**WELWYN HATFIELD BOROUGH COUNCIL
EXECUTIVE DIRECTOR - PLANNING, PUBLIC PROTECTION AND GOVERNANCE**

DELEGATED APPLICATION

Application No: 6/2020/2740/PN27
Location: 53 The Ridgeway Cuffley Potters Bar EN6 4BD
Proposal: Prior approval for the construction of an additional storey to facilitate the enlargement of the dwellinghouse to a maximum of approximately 8.68m in height.
Officer: Mr Antoine Commenville

Recommendation: Prior Approval Required and Refused

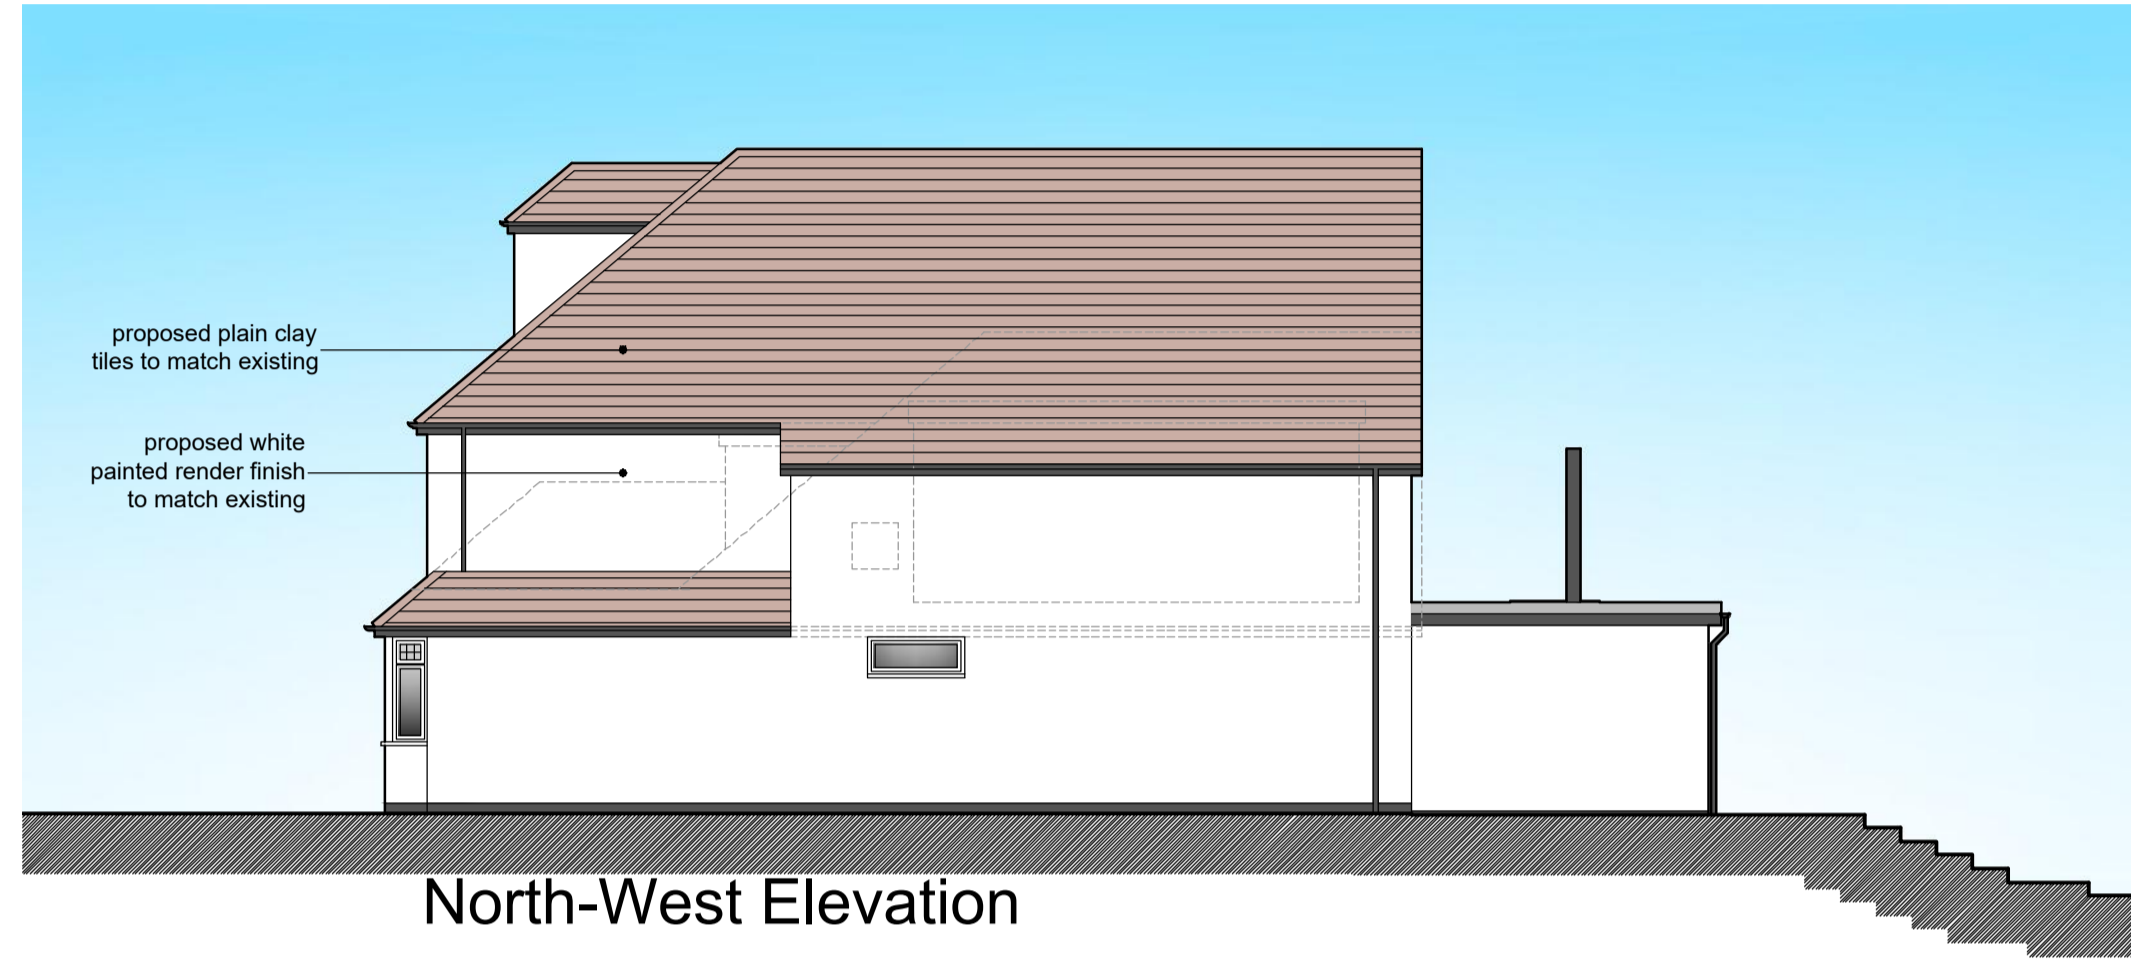
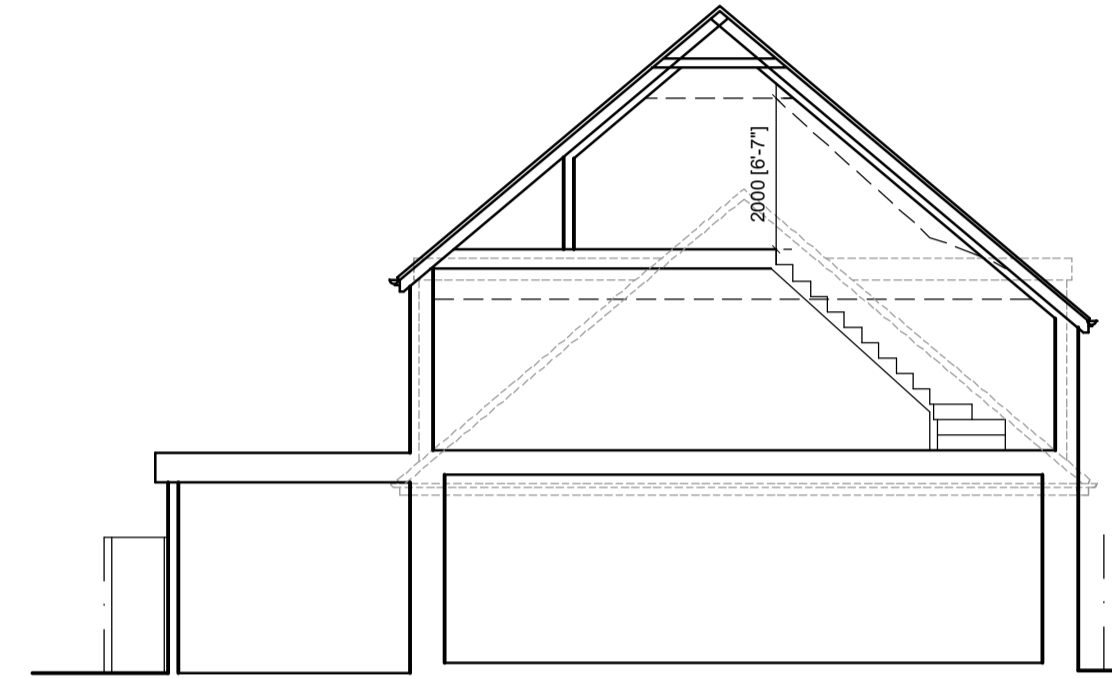
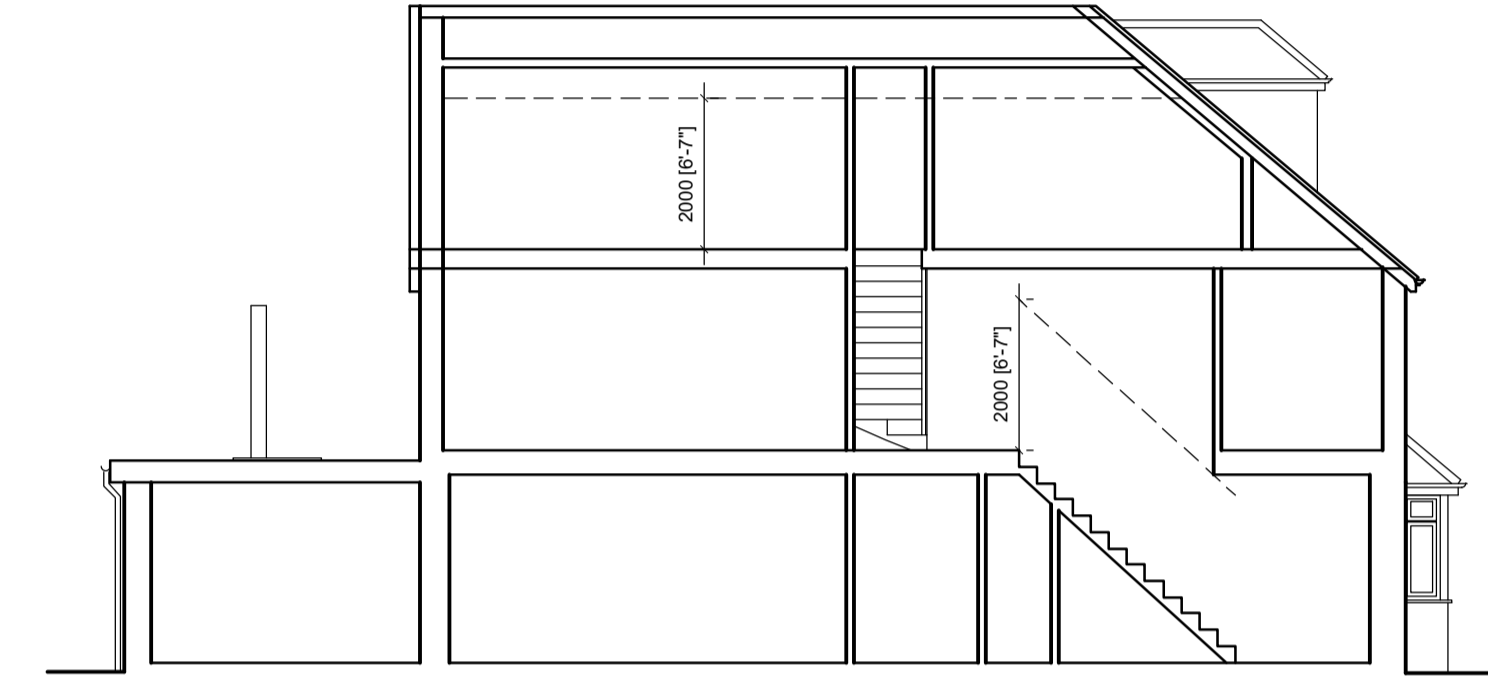
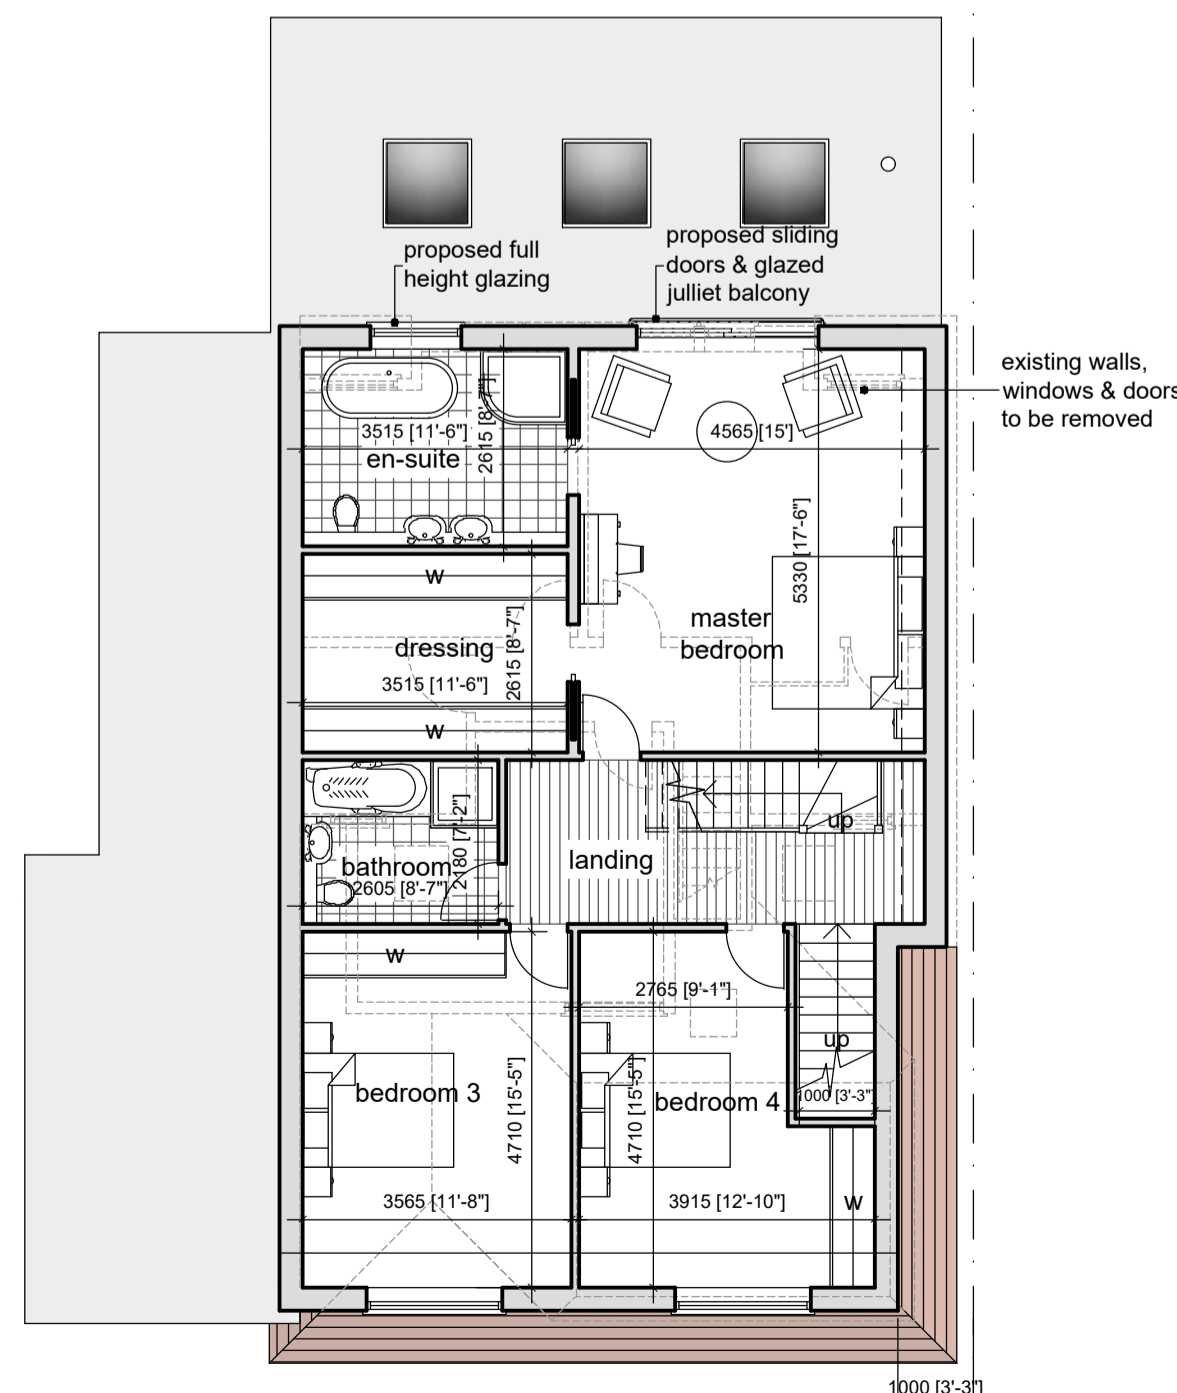
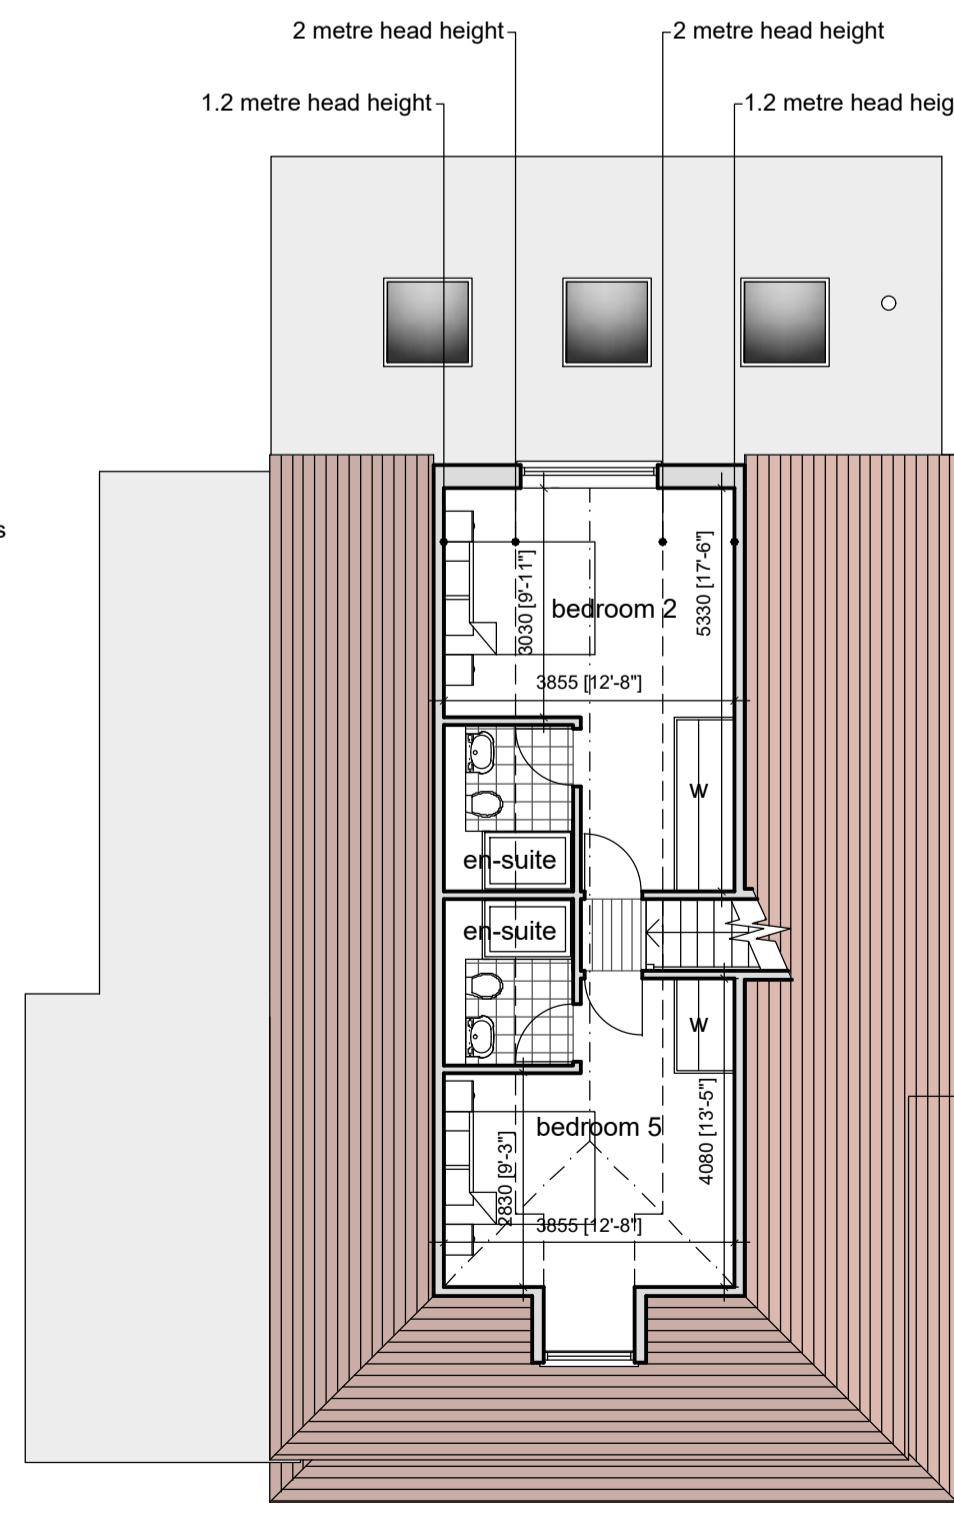
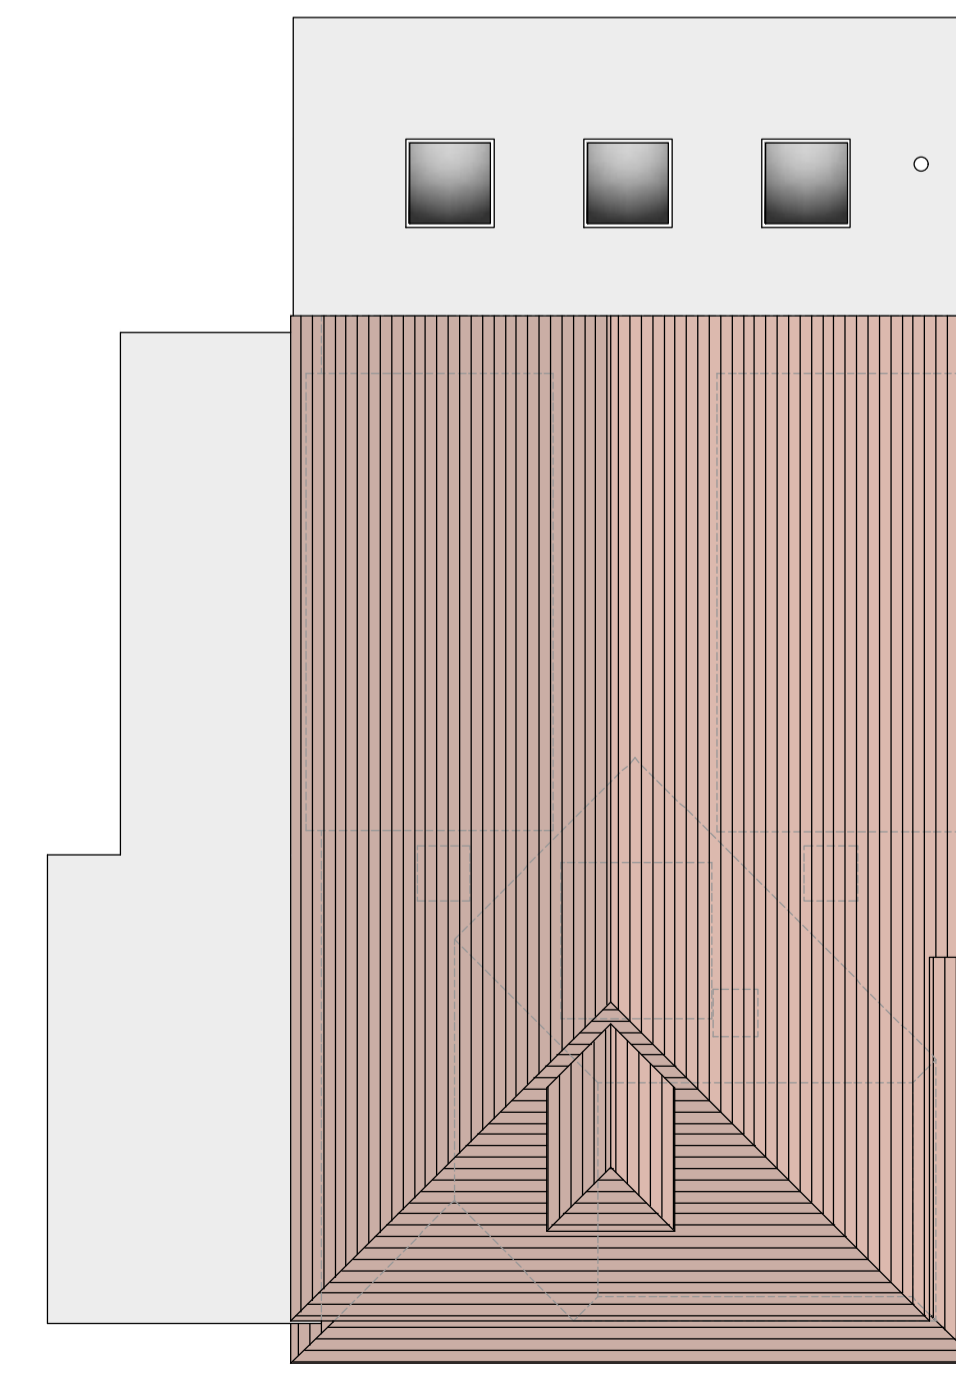
The property currently benefits from a single storey front extension approved under LPA E6/1965/2342/with a flat roof which has a lower height than the ridge of the existing dwelling. The proposed new storey would extend above the existing single storey flat roofed projection to create a two and half storey element, therefore it is considered an additional storey is constructed other than on the principal part of the dwellinghouse, in conflict with the above criteria.

The properties either side of the application site (51 and 55 The Ridgeway) are two storey in nature. The proposed additional storey would result in additional massing, bulk and built form at the address, however the resultant dwelling would feature a part pitched roof which pitches away from the boundary and it would not encroach upon the boundaries of the neighbouring properties any further than the existing property. The impact upon the neighbouring properties would therefore be acceptable as a result of the distance between the neighbouring properties and the extended dwelling as it would not be unduly over dominant or result in a significant loss of light to adjoining premises.

In regards to privacy, no side windows are proposed within the new storey of the existing dwelling. The proposed rear windows would serve bedroom and a bathroom at first floor and a bathroom at the second floor. It is noted that windows serving bedrooms currently exist at first floor. The proposed rear windows would afford views to the south of the site towards the residential gardens of 51 and 55 The Ridgeway. Nonetheless, the views would predominantly be to the rear garden of the application site. Whilst there is potential for overlooking to parts of the rear gardens of the neighbouring properties, due to the positions of the windows these would be at an oblique view rather than a direct view. Some degree of overlooking is also acceptable which would be consistent with a neighbouring relationship generally expected between residential properties. Subsequently the resulting relationship would not result in an undue loss of privacy.

(aa) the principal elevation of the dwellinghouse, and
(bb) any side elevation of the dwellinghouse that fronts a highway. The proposed additional storey to the dwelling would continue the existing roof form and style of the original dwelling, including the pitched roof and architectural features. The proposed windows

would be in keeping with the style and fenestration pattern of the principal elevation of the existing dwelling too. In addition, the additional floor and roof would be constructed using matching materials to the existing dwelling. On this basis it is considered the design and architectural features of the resultant dwelling would respect the principal elevation and design of the existing dwelling.
Air traffic and defence impacts	The dwelling would have minimal impact on air traffic and defence assets.
Whether because of the siting of the building, the development will impact on a protected view	The development would not impact on a protect view identified in the Directions Relating to Protected Vistas.
<p>RECOMMENDATION Prior approval required and refused</p> <p>The proposal has been assessed against Schedule 2, Part 1, Class AA of the Town and Country Planning (General Permitted Development) (England) Order 2015 as amended and prior approval is required and refused for the following reason:</p> <ol style="list-style-type: none"> The additional storey would be constructed above a part of the property which is not the principal part of the dwellinghouse. The proposed development therefore conflicts with Paragraph AA.1 (i) of Class AA, Part 1 of Schedule 2 of the Town and Country Planning (General Permitted Development) Order 2015 (as amended).

- The additional storey would be constructed above a part of the property which is not the principal part of the dwellinghouse. The proposed development therefore conflicts with Paragraph AA.1 (i) of Class AA, Part 1 of Schedule 2 of the Town and Country Planning (General Permitted Development) Order 2015 (as amended).
